Construction of 1No. 2 bedroom chalet bungalow
Land adj to 65B Gravits Lane Bognor Regis

Thank you for your internet representation made on 11th September 2014 which has been recorded as '**an objection**' with the comments as follows:

BLOCK / LOCATION PLAN
LAND ADJACENT TO 65B GRAVITS LANE BOGNOR

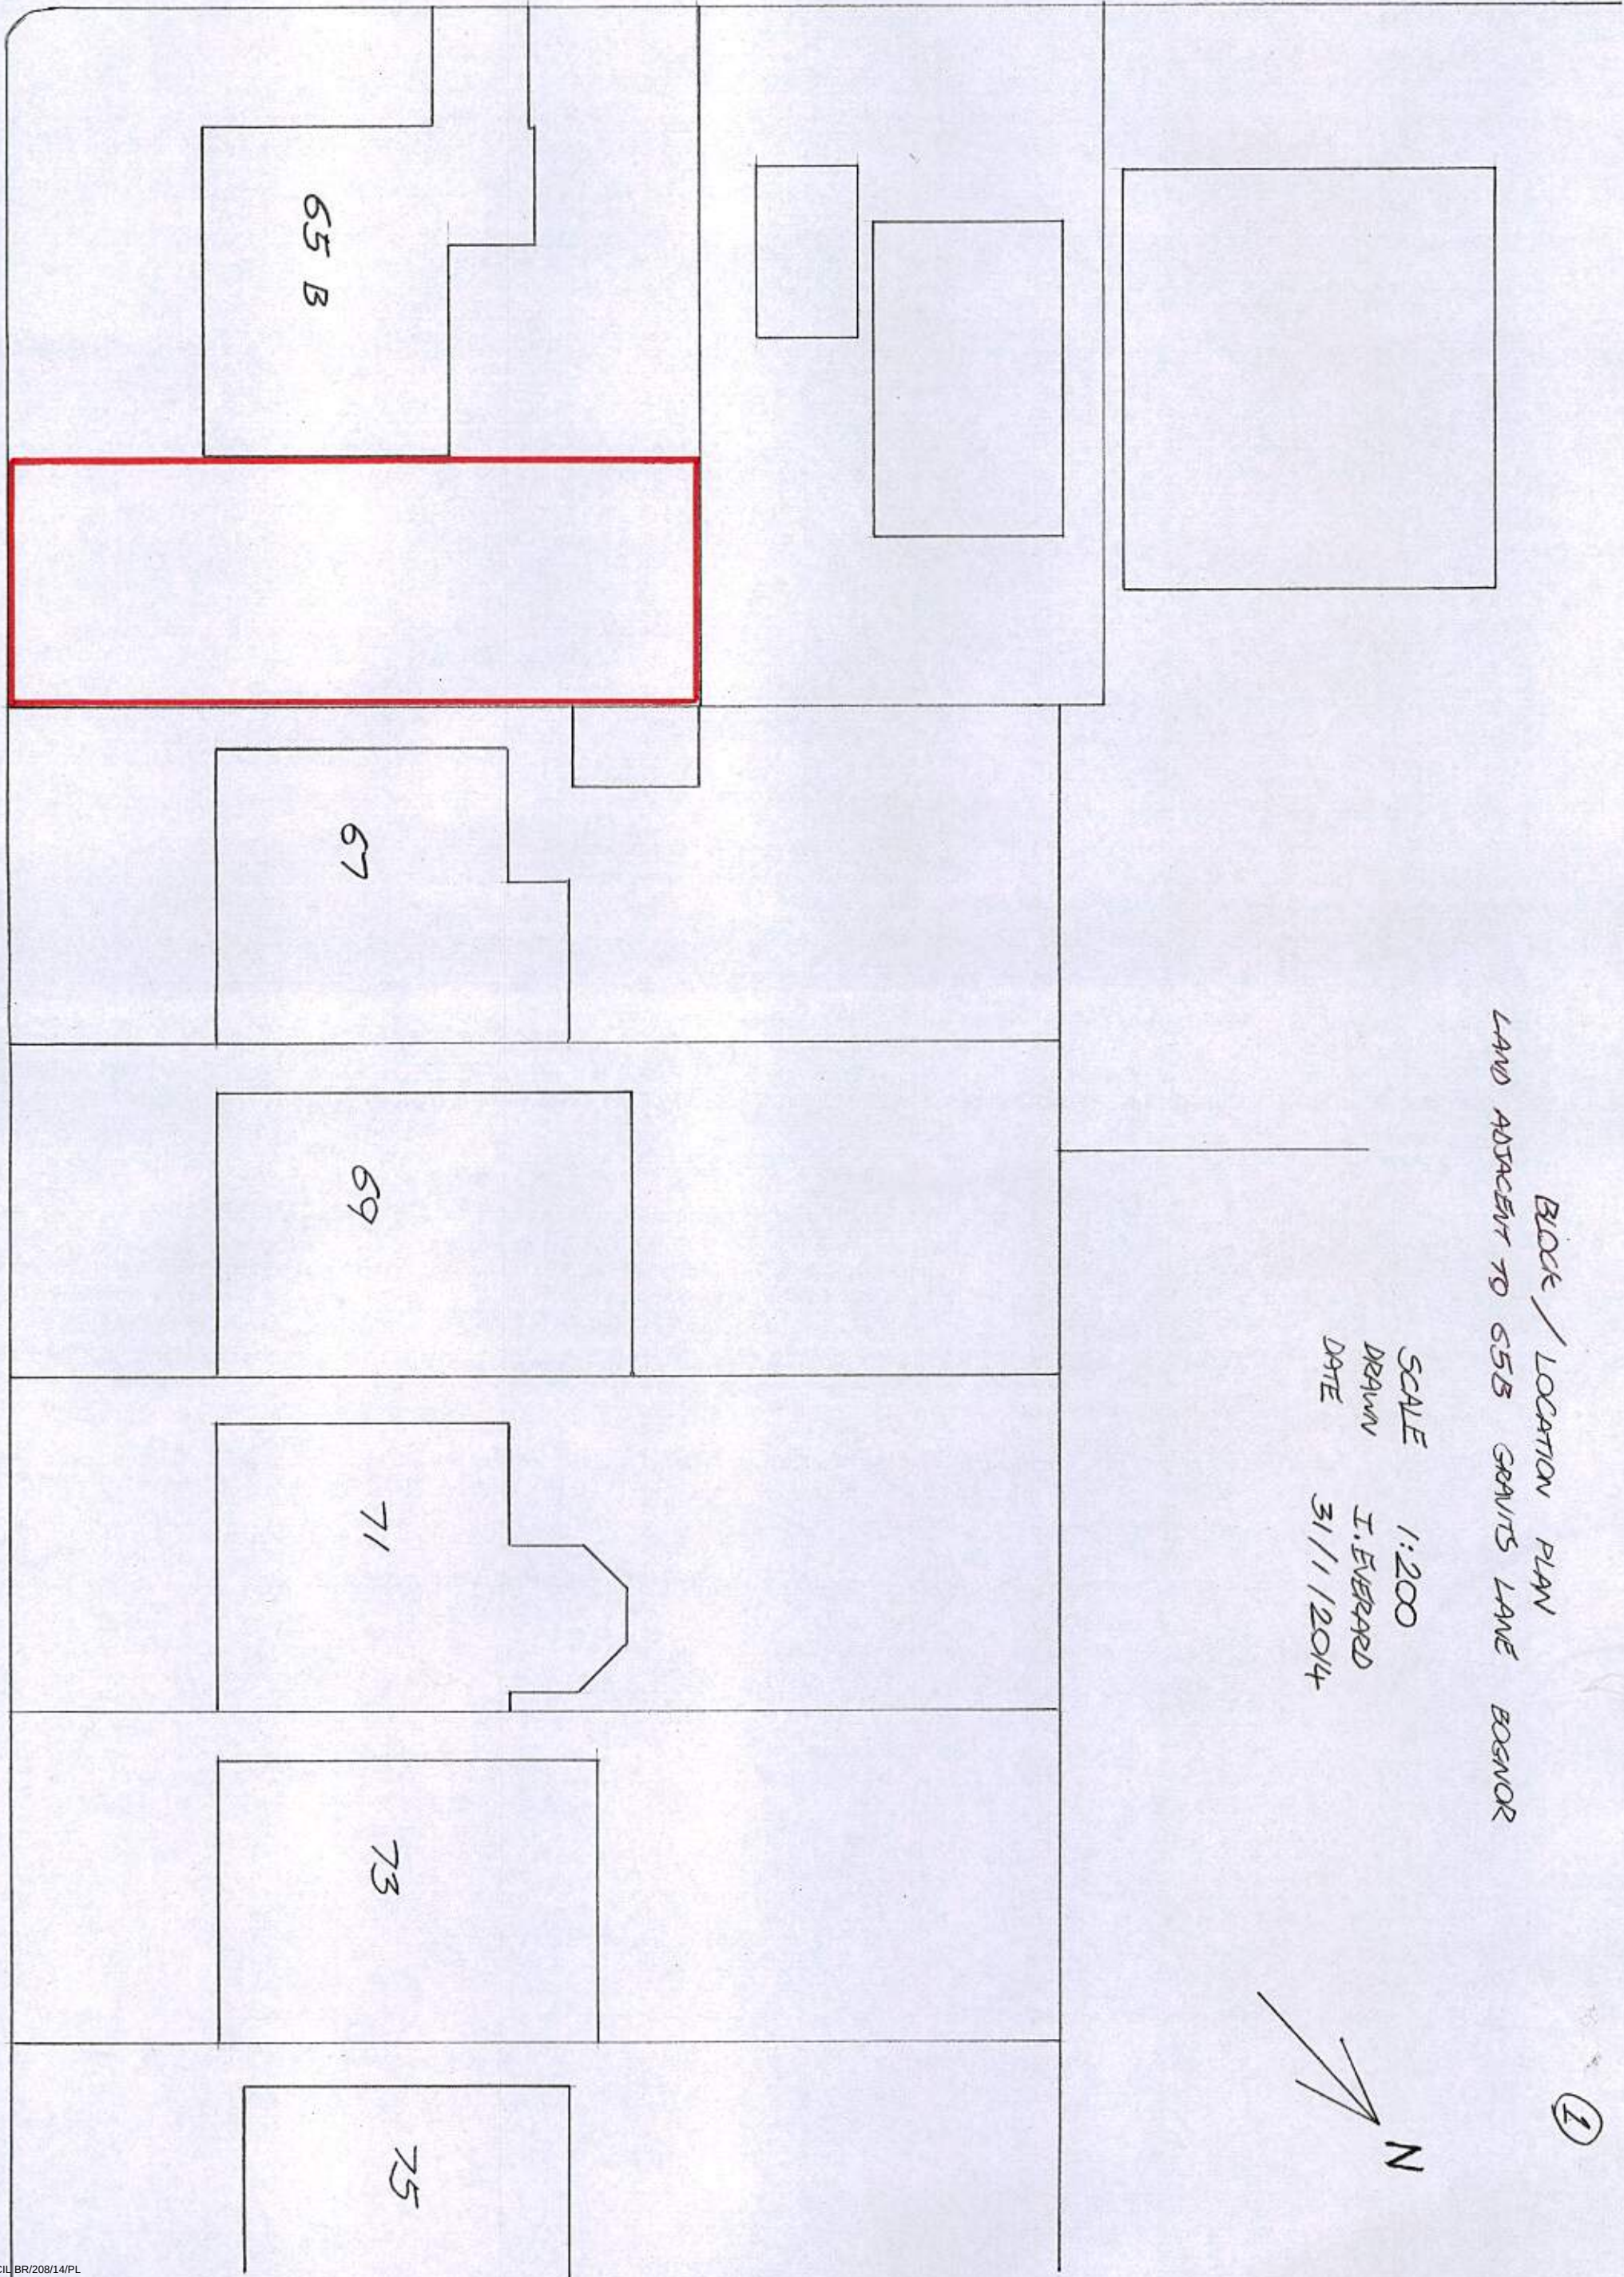
I highly recommend that this development does not go ahead on the grounds that with the redevelopment of 65b which used to be two properties with access to property for 2 ivydale on the side, now being a 5 double bedroom property. Only 2 car spaces are available now for this property. It has been said this property is being bought by someone who will be letting the rooms out which in no doubt have more that 2 cars. This will make more cars parked outside the property on a corner that is already a blind spot. Placing the driveway nearer to this corner will no doubt cause problems for seeing anyone leaving the driveway.

Access to sub water station I feel will be a problem for large vehicles if more cars parked out new development, as only one car space is being allowed.
